Your ref: SSD-79316759
Our ref: DOC25/275573

2 May 2025

Subject: Environmental Impact Statement – Concept Proposal for Mixed Use with Affordable Housing – 45-53 Macleay Street, Potts Point (SSD-79316759)

CPHR advice on EIS – Concept Proposal for Mixed Use with Affordable Housing – 45-53 Macleay Street, Potts Point (SSD-79316759)

19/2/2025 MGA 56

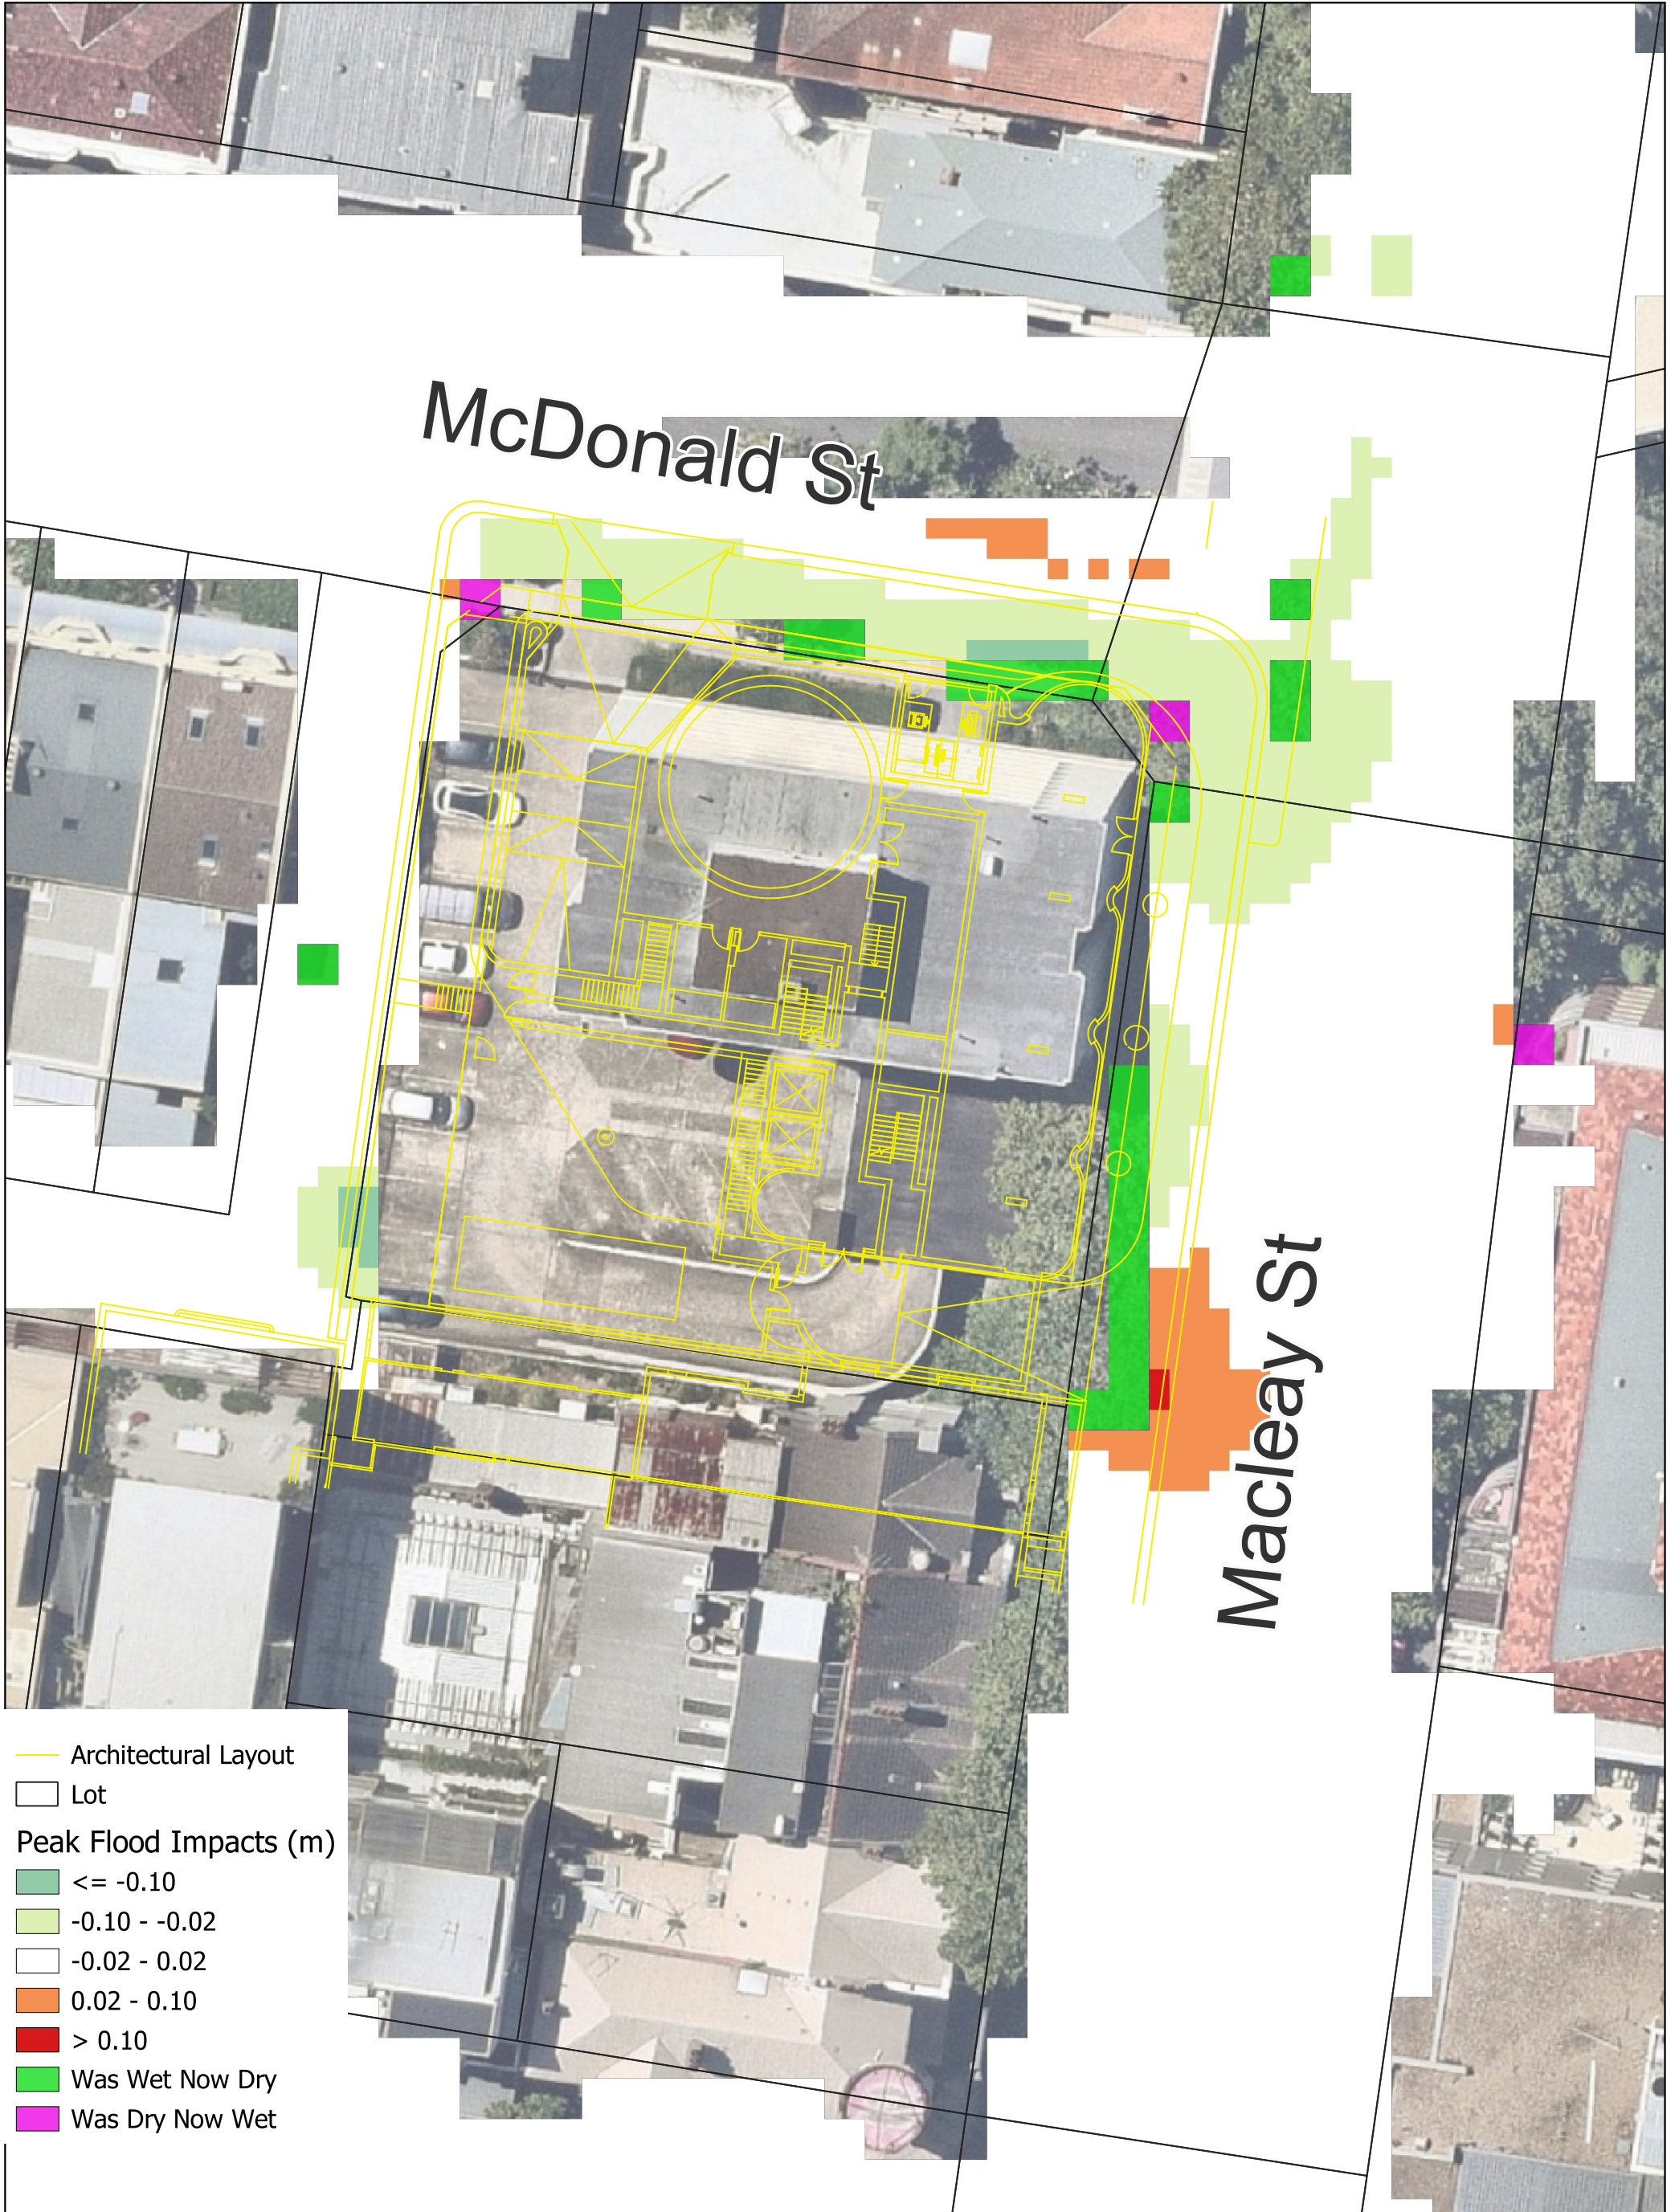
1.	<i>Flood levels in Macleay Street exceed recommended increases</i>	<p>The FIRA indicates that the post-construction flood level will increase by approximately 100 mm in a small section of kerb area in Macleay Street. This increase is attributed to changes in the footpath profile to meet Council's required footpath and flood planning levels for the development. CPHR considers that this impact could be mitigated by appropriate tie-in works to the existing footpath across the front of the adjoining property.</p> <p>Recommended action:</p> <ol style="list-style-type: none"> 1. The conditions of consent include a requirement for tie-in works between the proposed raised footpath and the existing footpath on Macleay Street to minimise increases in the roadway's flood level.
	<i>Extent and Timing</i>	Determination during detailed design.
